V-1 Site Development Plan Redlines.pdf Markup Summary

SOLBERG PIT - SITE DEVELOPMENT PLAN

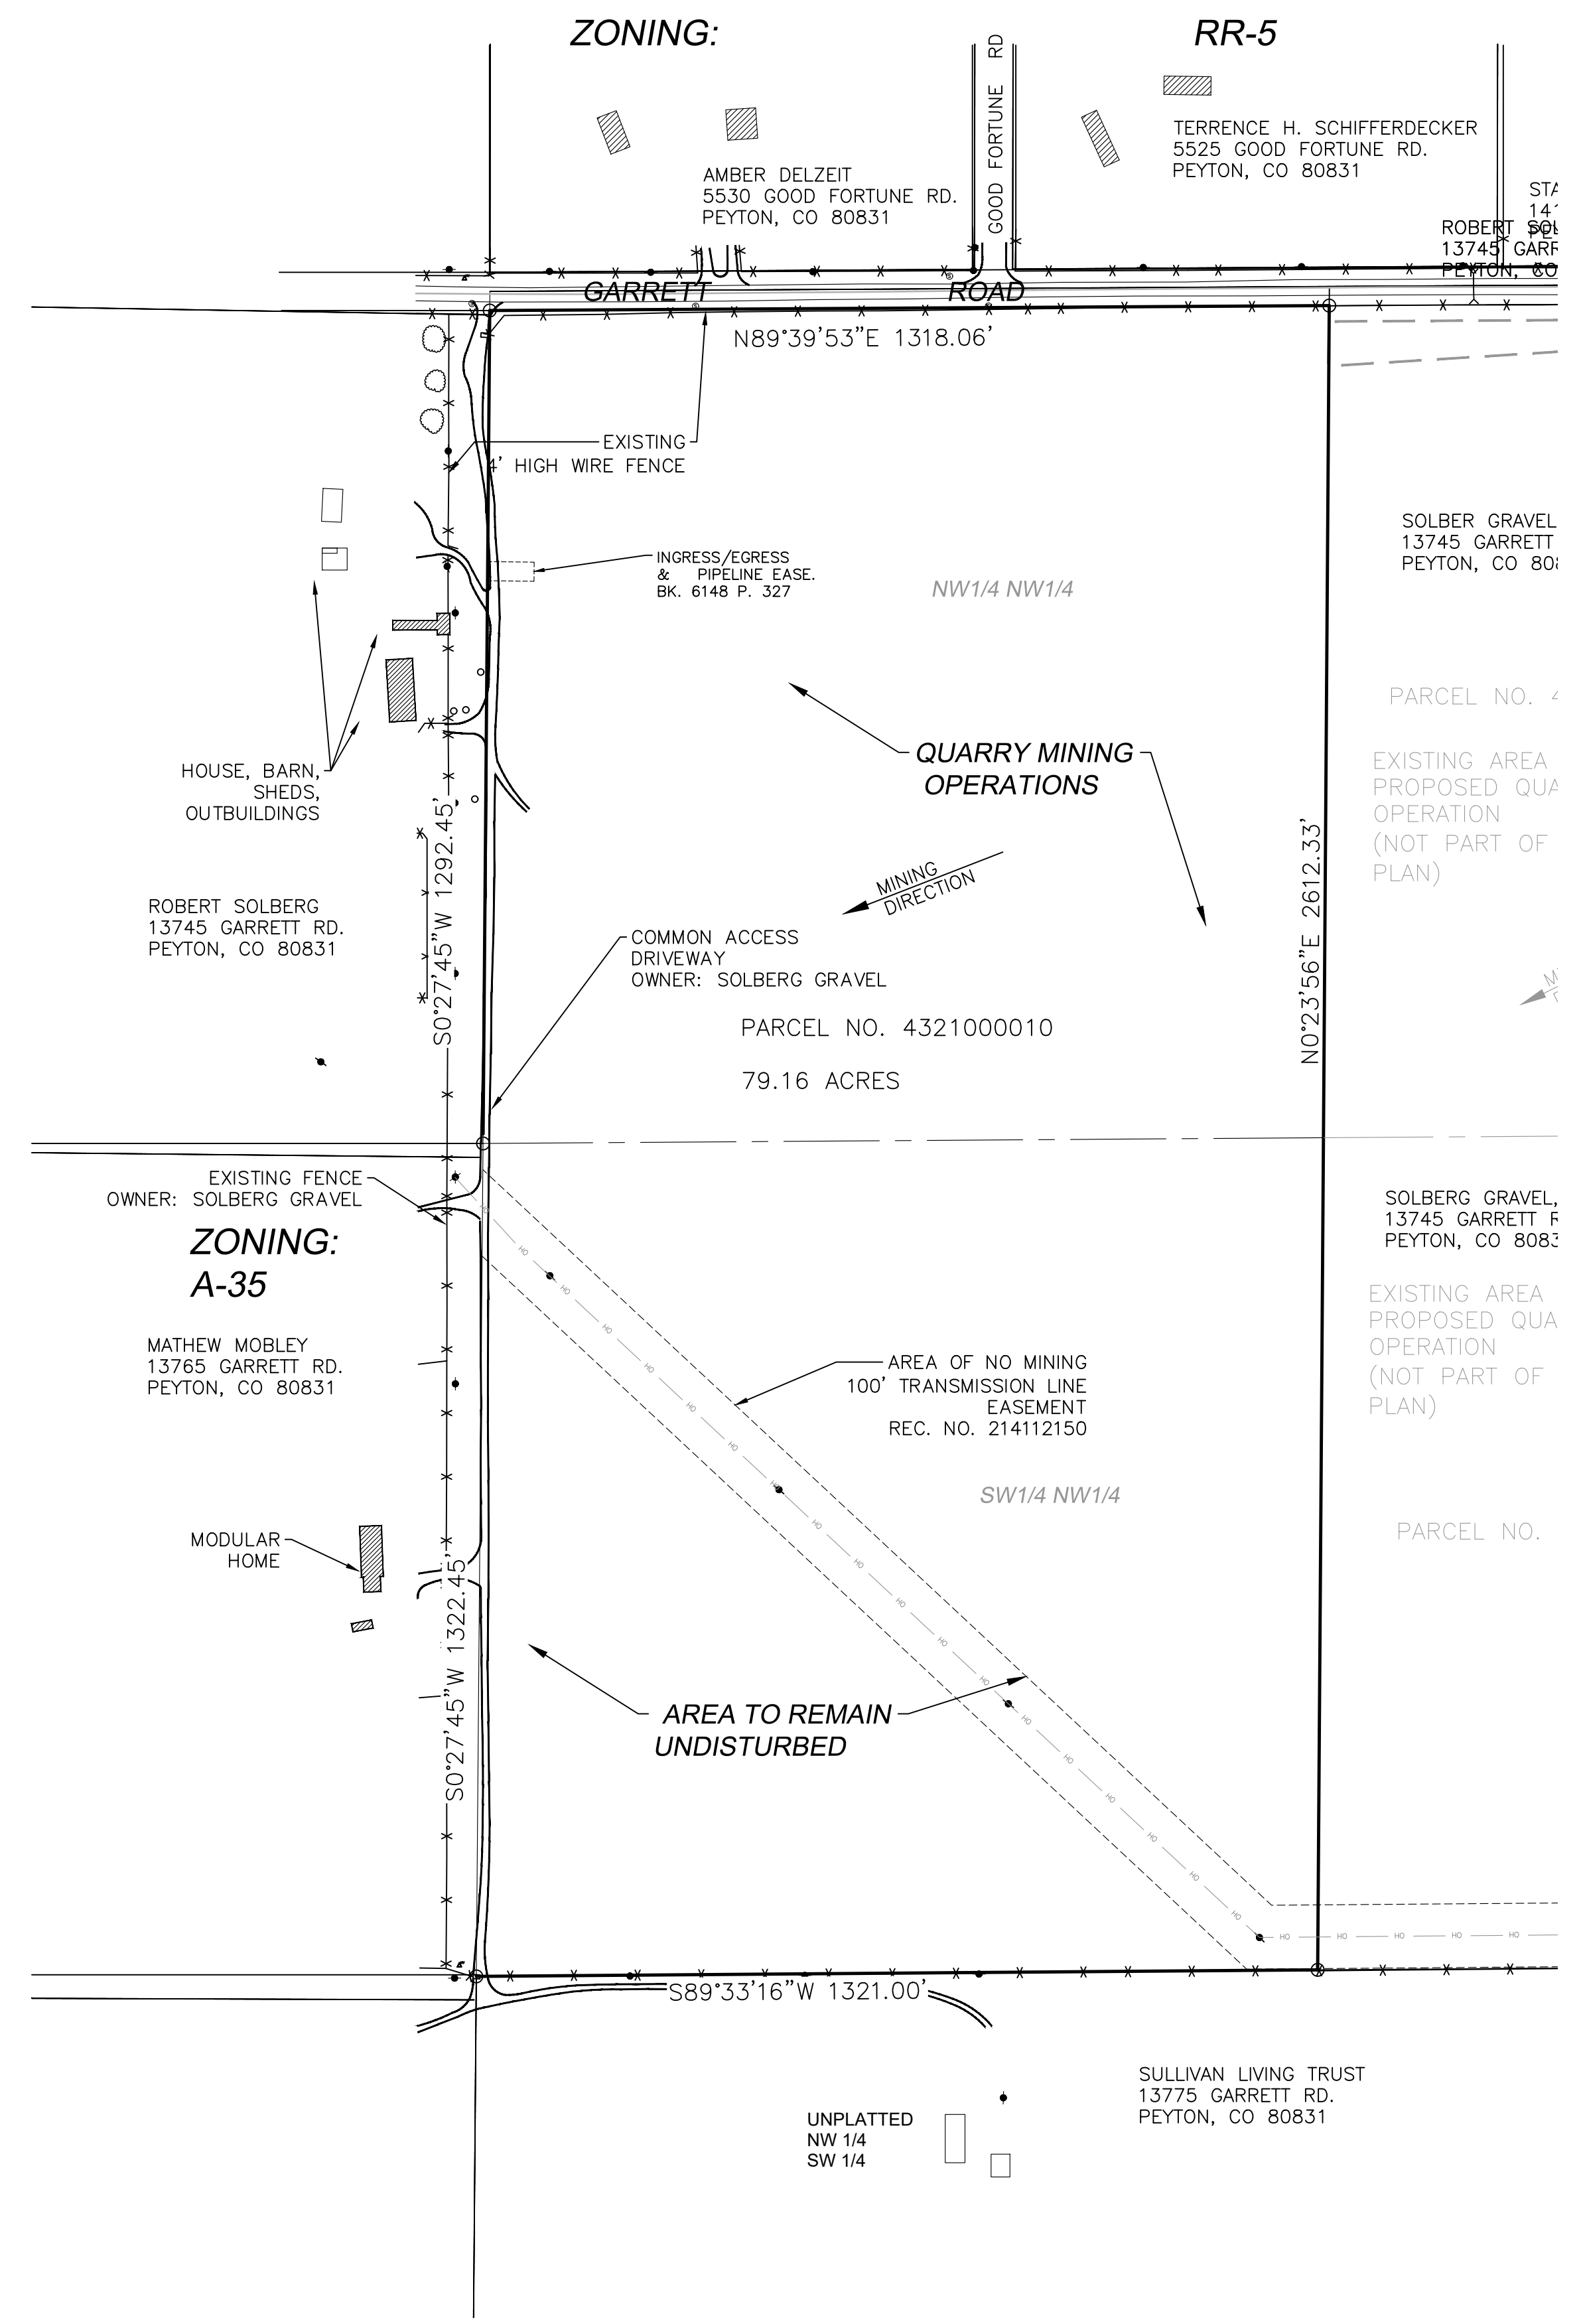
Add: PCD File No. PPR2432

Add: Any alteration of the site not in conformance with the approved site development plan in the future will require review by PCD.

Add note: All site traffic will enter and exit from Curtis Road entrance.
